WELWYN HATFIELD COUNCIL – DEVELOPMENT CONTROL
DELEGATED REPORT

APPLICATION No:	S6/2007/1648/FP
------------------------	------------------------

This application seeks full planning permission for the erection of a single storey front extension.

CLIENT	F Greaves Esq.
PROJECT TITLE	15 Theobalds Road, Cuffley
DRAWING TITLE	Existing & Proposed Plans

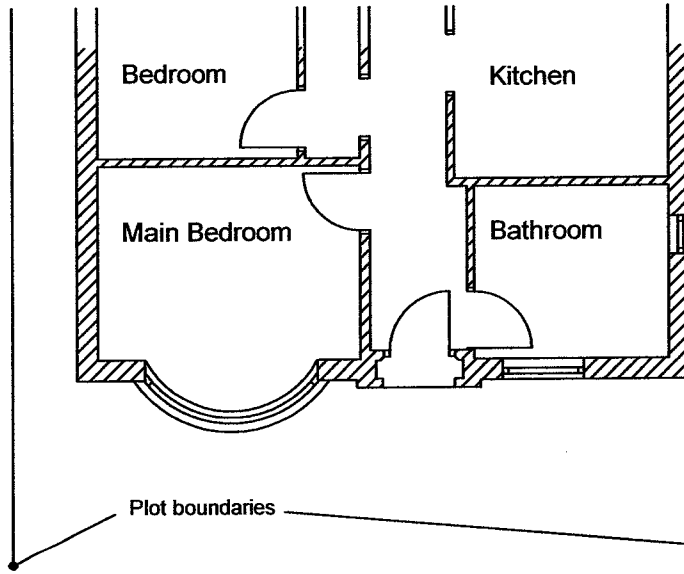
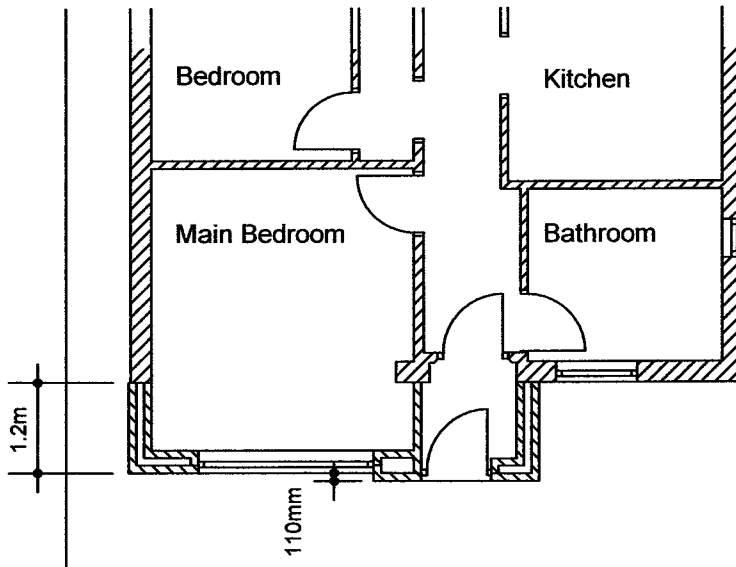
The proposed extension measures 5.5m width x 1.2m depth and would replace the existing bay window and porch. The proposed extension would have a part flat roof 3m in height and part hipped roof above the proposed porch 4.3m in height. It is proposed to finish the flat roof with felt covering and the pitched roof with tiles to match existing. The window and door would be constructed from white PVCu.

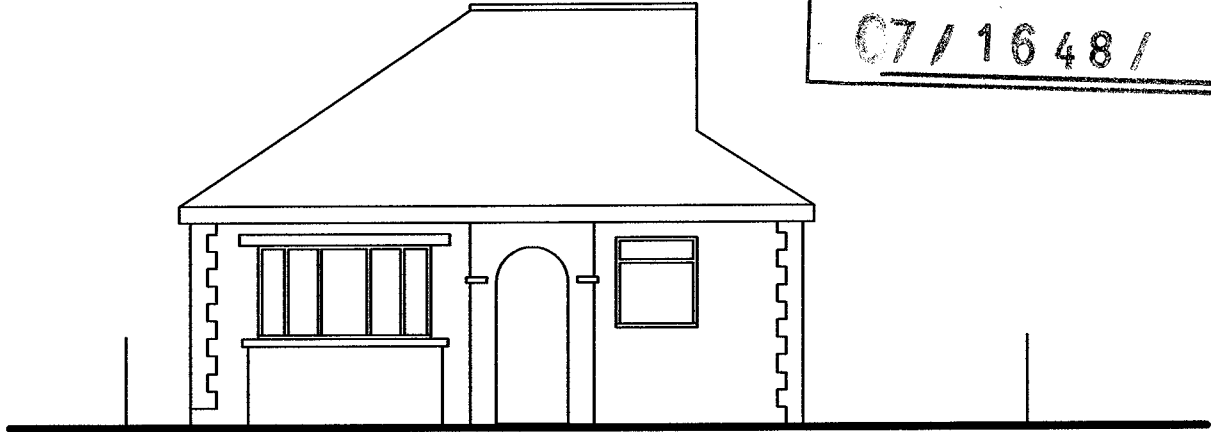
A number of properties within Theobalds Road have extensions and loft conversions, but most retain their original frontage at ground floor including the original bay window and arch over the porch displaying a unity of form which is pleasing. The proposed extension has not been designed to compliment and reflect the character of the existing building and its location. In particular the introduction of a flat roofed extension to the front of the dwelling would be uncharacteristic of the immediate street scene. The existing bay window and arched entrance are original features intrinsic to the character of the dwelling. Their loss would have a negative impact in design terms and a negative impact on the character and context of the area. The proposal therefore fails to comply with Policy D1 and D2 of the Welwyn Hatfield District

1. The proposed extension has not been designed to compliment and reflect the character of the existing building and its location. In particular the introduction of a flat roofed extension to the front of the dwelling would be uncharacteristic of the immediate street scene. The existing bay window and arched entrance are original features intrinsic to the character of the dwelling. Their loss would have a negative impact in design terms and a negative impact on the character and context of the area. The proposals are therefore contrary to Policies D1 and D2 of the Welwyn Hatfield District Plan 2005 and Supplementary Design Guidance (Statement of Council Policy).
